PINE VIEW ESTATES FILING NO. 1 PRELIMINARY PLAN

PCD FILE NO: SP-20-004

**PINE VIEW ESTATES
FILING NO. 1
PRELIMINARY PLAN**

PRELIMINARY PLAN

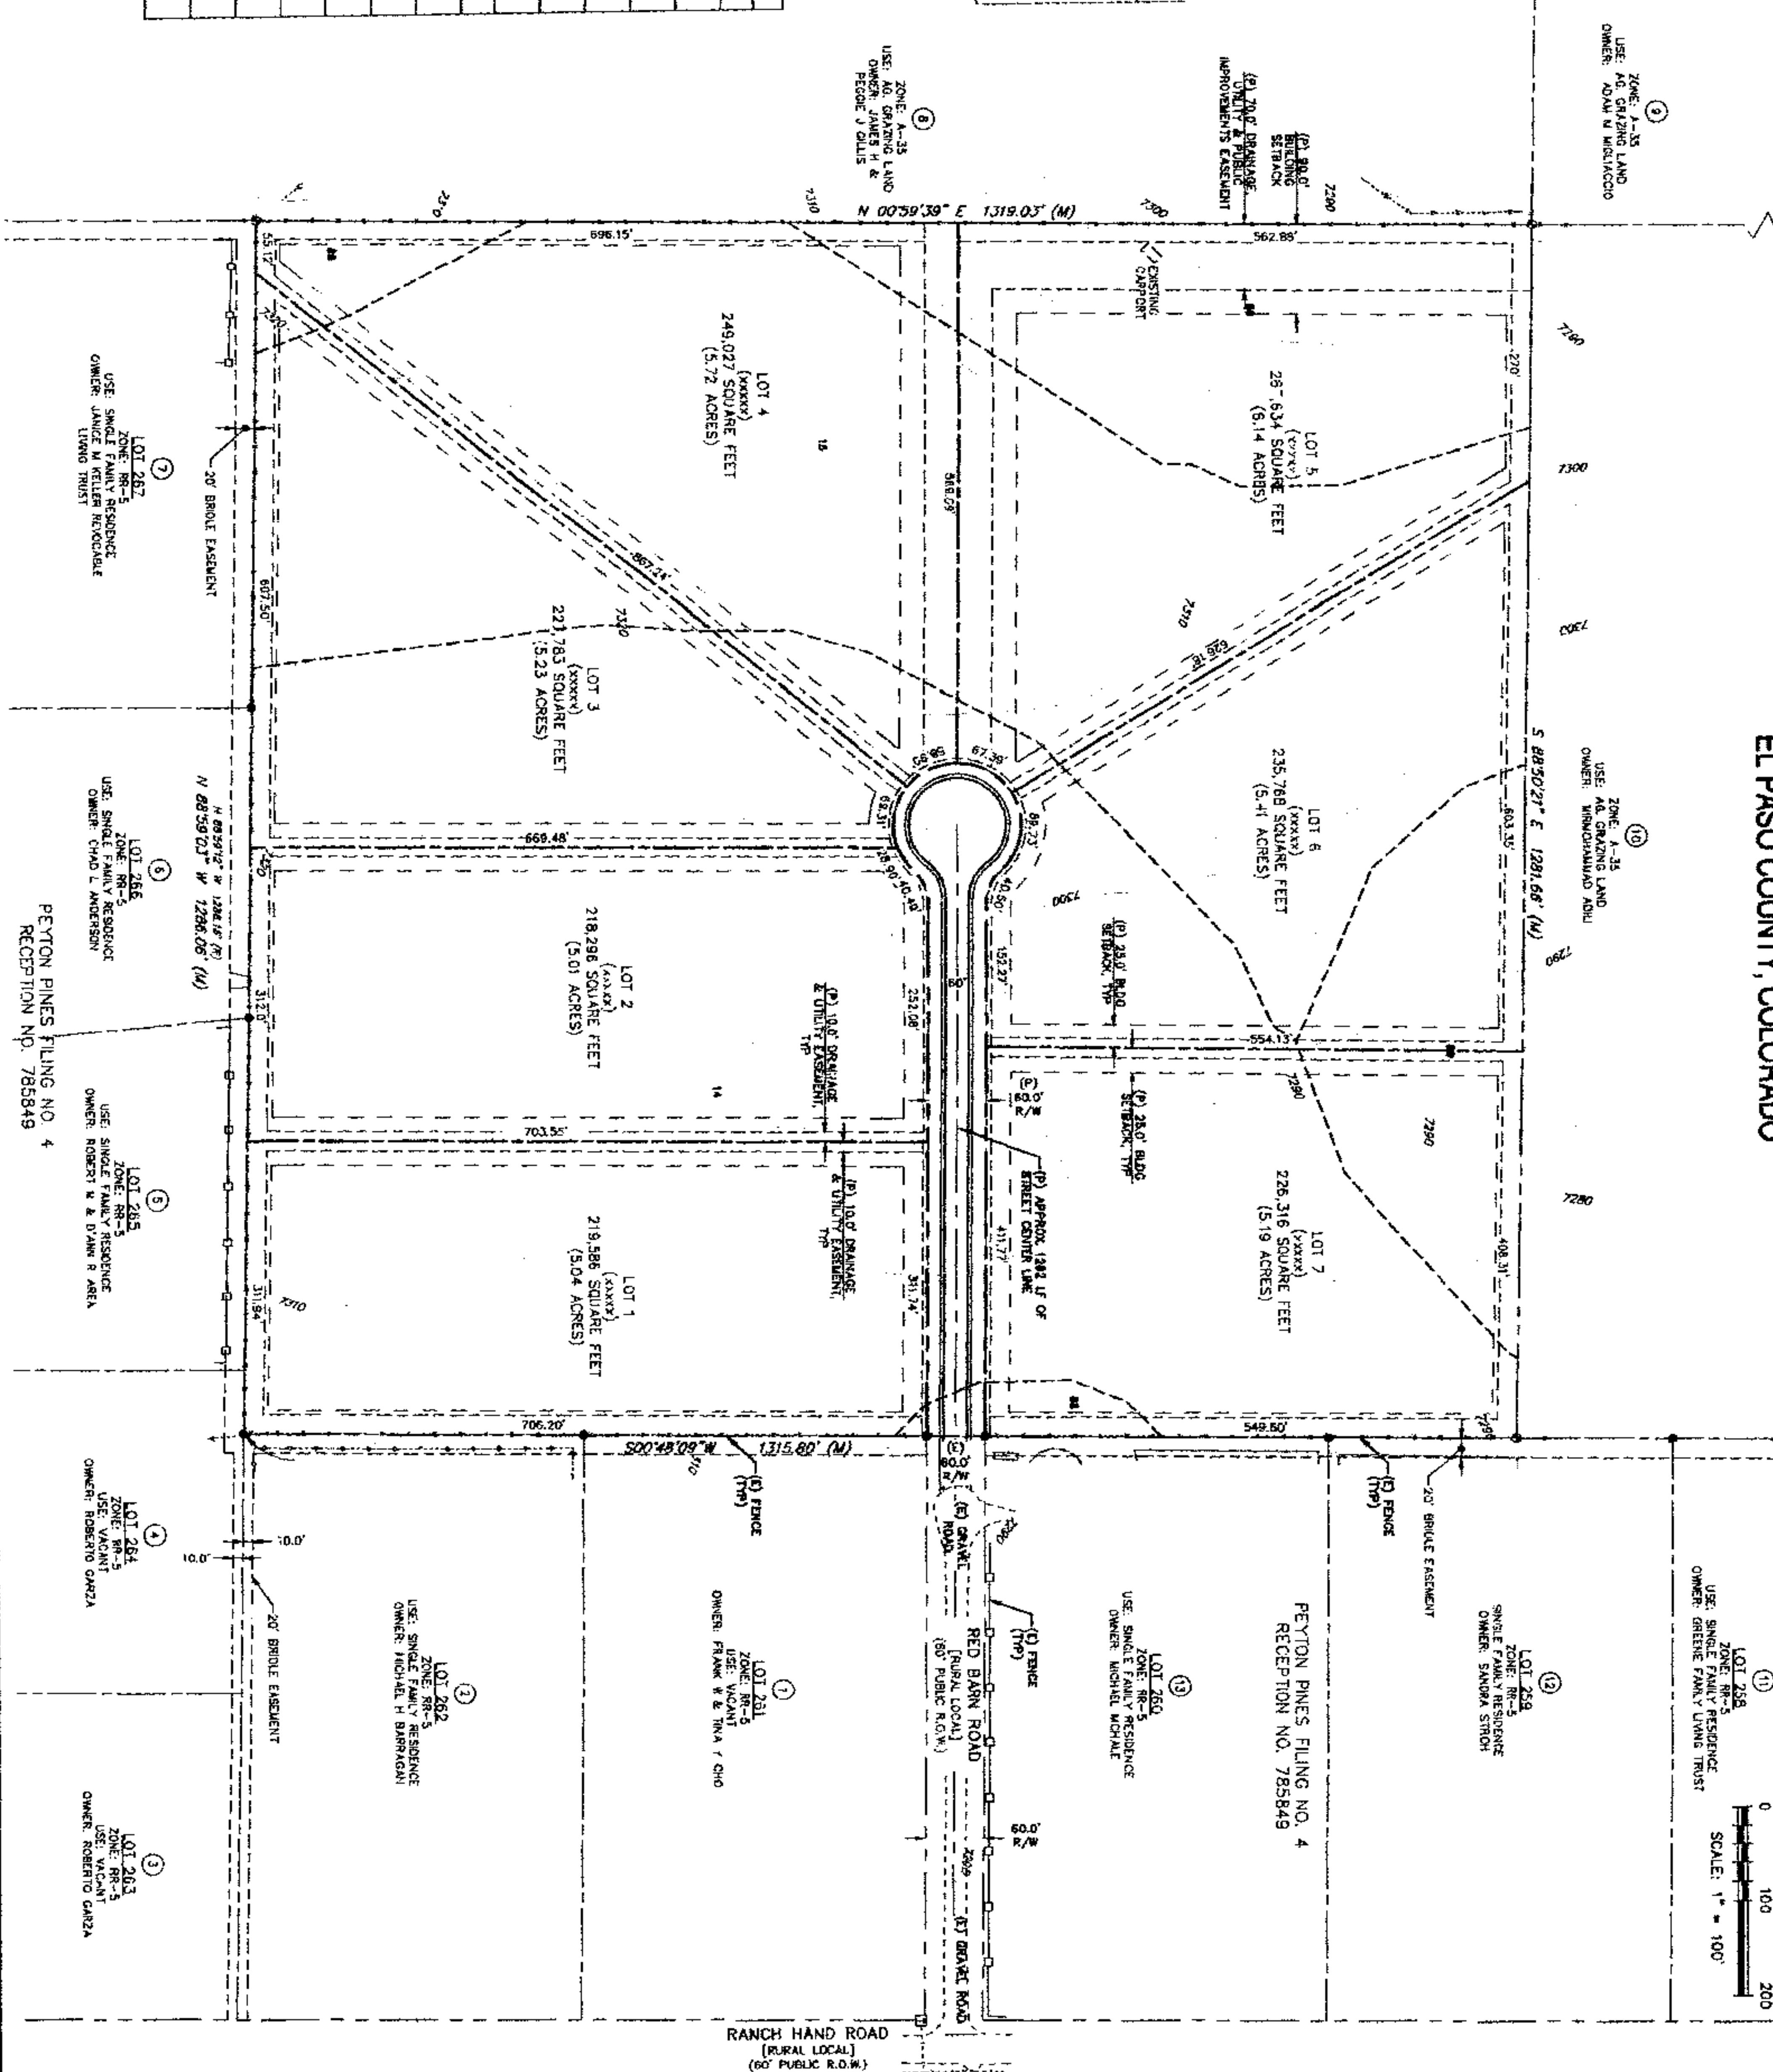
After staffs discussion with the County Attorney and with other engineering staff, the connections to the west and north should just be indicated as public ROW similar to what is done for red barn road. Please adjust the property lines for lots 3 & 4 accordingly. Please feel free to call me (719-208-6783) if you'd like to discuss.

Please clarify the significance of the soil area boundaries. Are these hazard areas that should be on the plat also? Also staff suggests using a different line type as it is very similar to the easement line type.

Review I comment: Identify what the interior black line is at the proposed roadway.

Review II comment: Please label the road edge. Unresolved.
